**Albuquerque
Metropolitan
Arroyo
Flood
Control
Authority**

Re: Access Easement on AMAFCA Tract B as related to Parkway, Unit 10
City Project No. 627481

Re: Parkway Subdivision Unit 10
 AMAFCA Field Visit

Re: Parkway Unit 10 Grading & Drainage Plan, Engineer's stamp dated 6-25-02 (J9/D17)

City Project #627481, Map J9, Sheet 2 of 2

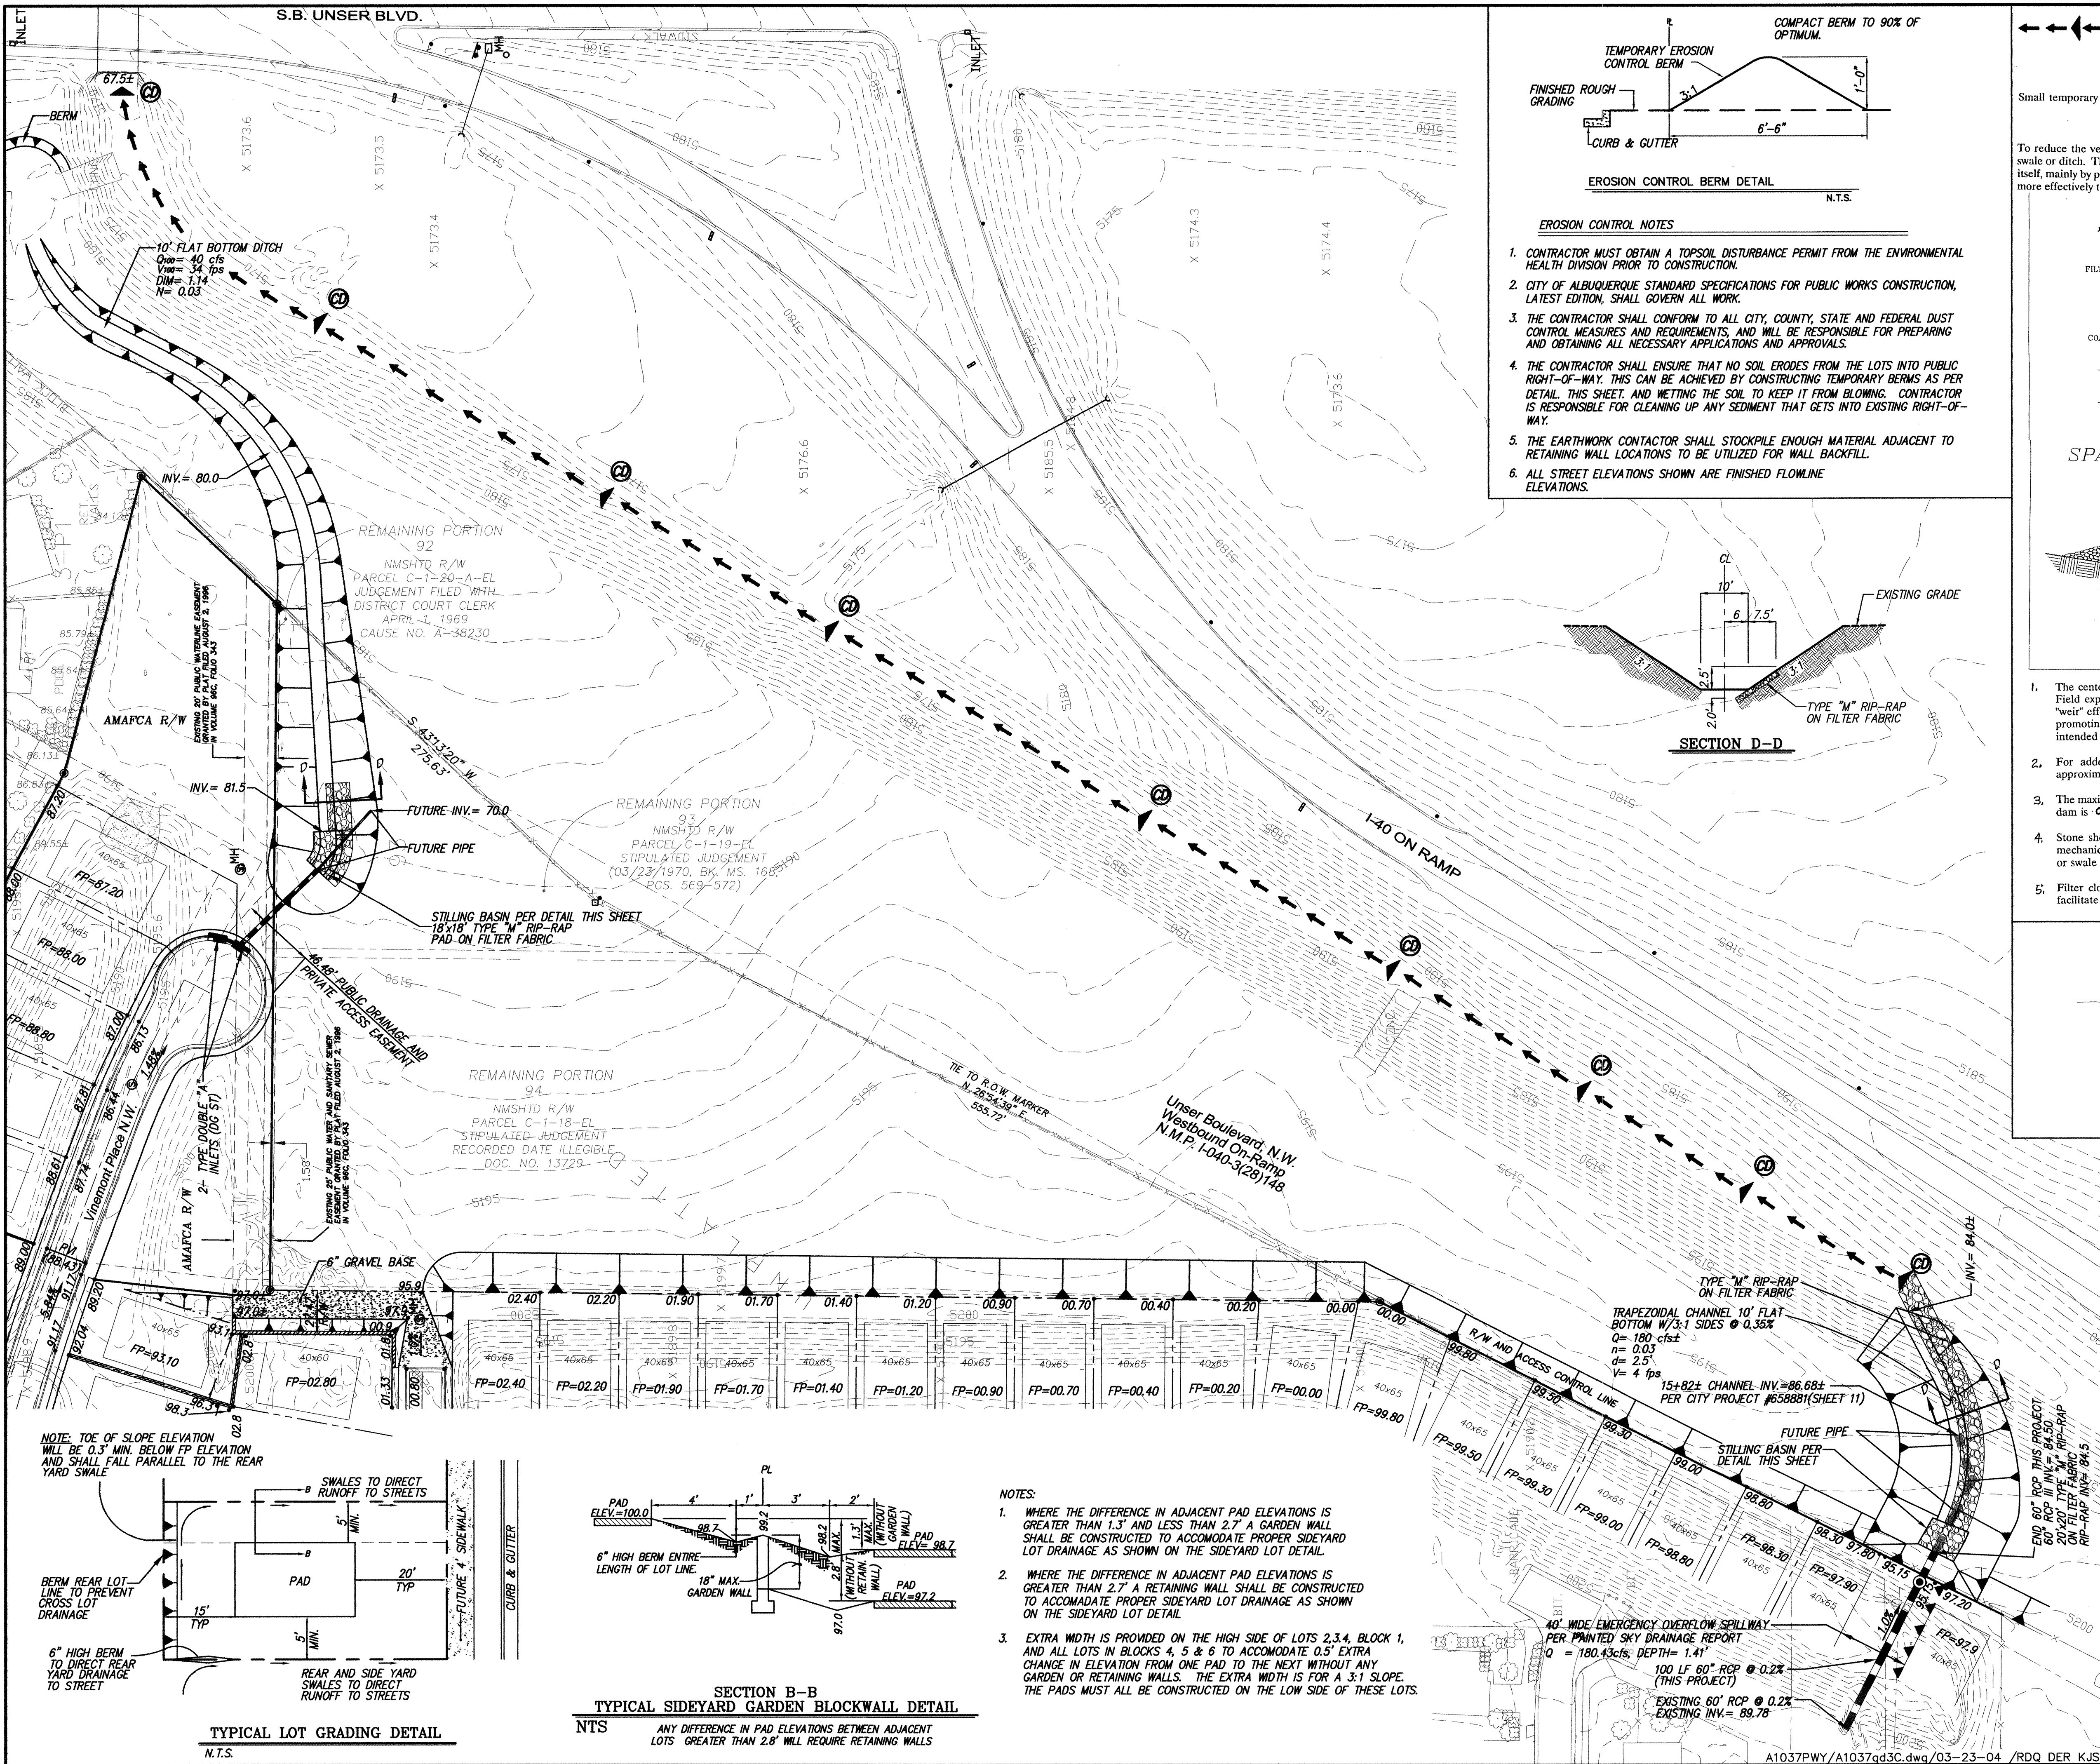
1. The 60-inch storm drain outlet
 - a. The stilling basin was not constructed per the plans and profiles
 - b. The unprotected 0.5:1 slopes around the 60-inch pipe is unacceptable.
 - c. The type "M" riprap was not constructed per the plans and profiles.
2. Check Dams
 - a. The check dams were not constructed per the plans and profiles.
 - b. Check dams do not extend to existing banks
3. The 30-inch storm drain outlet
 - a. The stilling basin was not constructed per the plans and profiles
 - b. The unprotected 0.5:1 slopes around the 30-inch pipe is unacceptable.
 - c. The type "M" riprap was not constructed per the plans and profiles.
 - d. The earthen channel is not graded to drain.
 - e. The earthen at Unser needs to be re-worked.
